**Re: Kirkpatrick  
8610 President Place  
Request Permanent C.O. - Accepted  
Engineer's Stamp dated: 2-5-15 (C17D122)  
Certification dated: 9-14-15**

**RE: Kirkpatrick Warehouse (File: C17D122)**  
**Grading and Drainage Plan, Engineer's Stamp Date 2-5-15**  
**Drainage Report, Engineer's Stamp dated 11-25-14**

**KIRKPATRICK WAREHOUSE  
TRACT B1A5, CLIFFORD INDUSTRIAL PARK  
8610 PRESIDENTS PLACE  
Albuquerque, New Mexico**

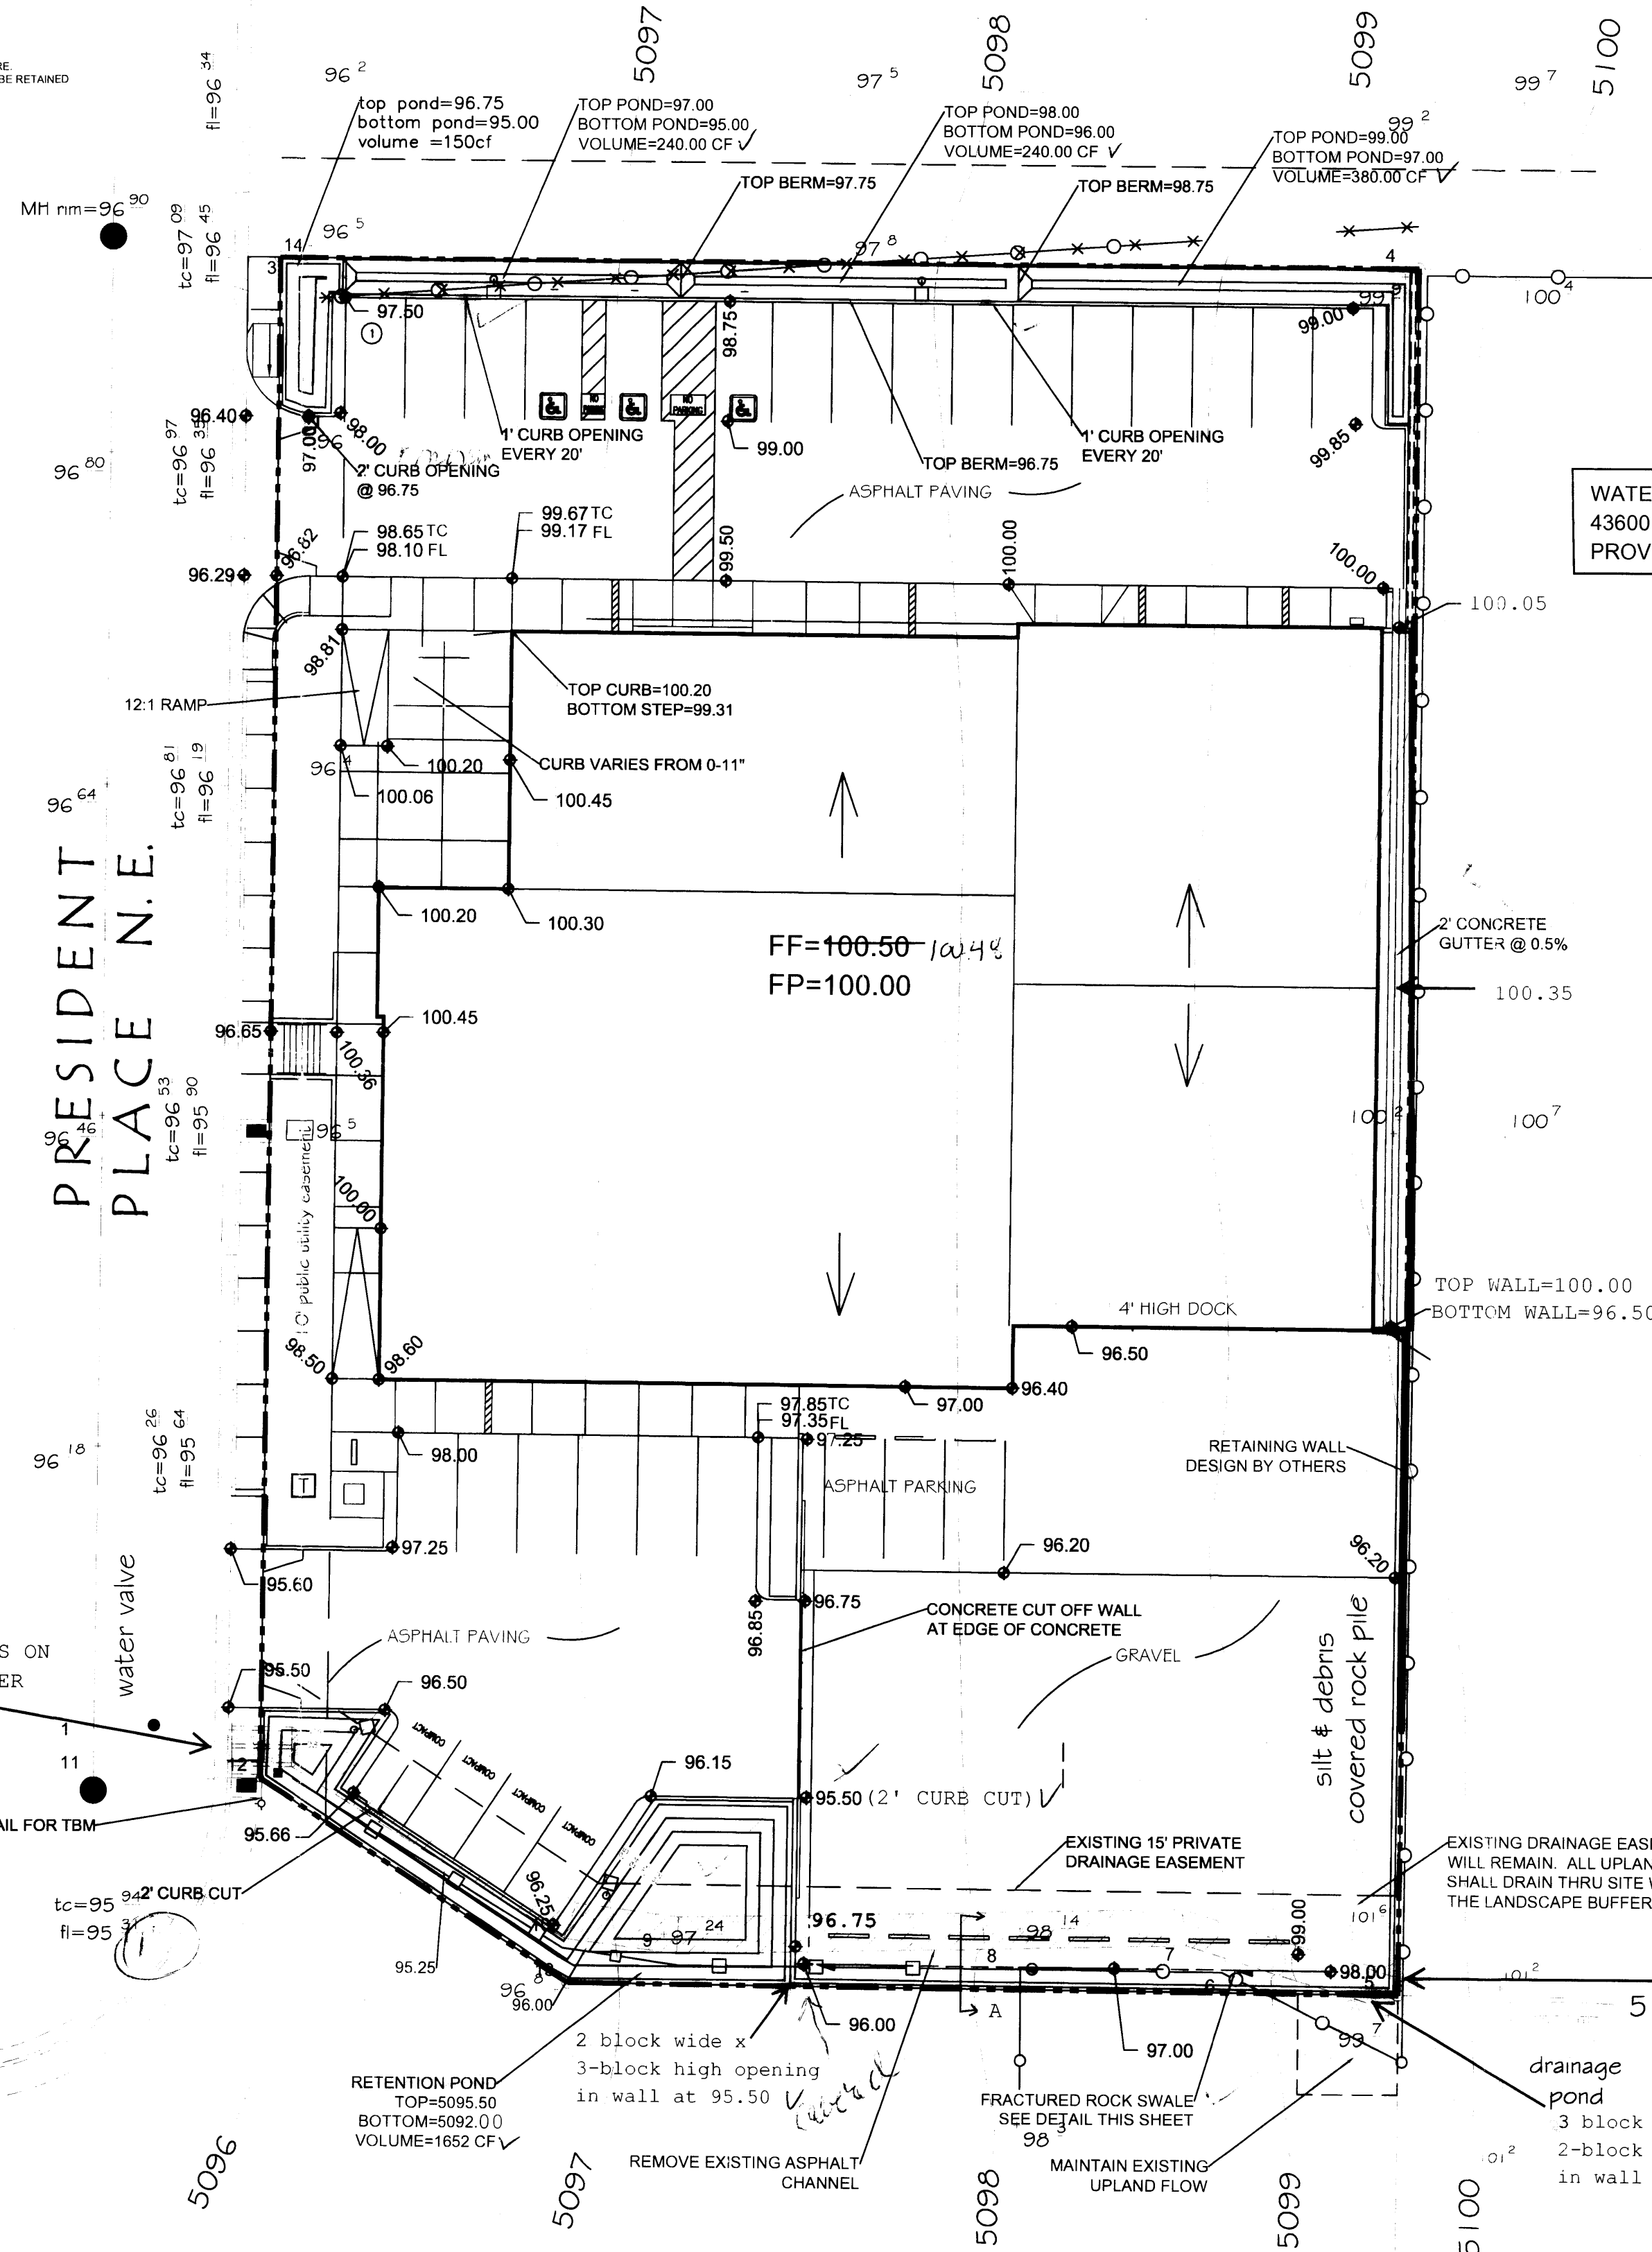
- Add rip-rap where the drainage channel along the south side discharges to the retention pond.
- Note that the fence is to be removed.
- Limit the diameter or size of any landscaping that is to be put within the channel so that the capacity of the channel is not reduced.
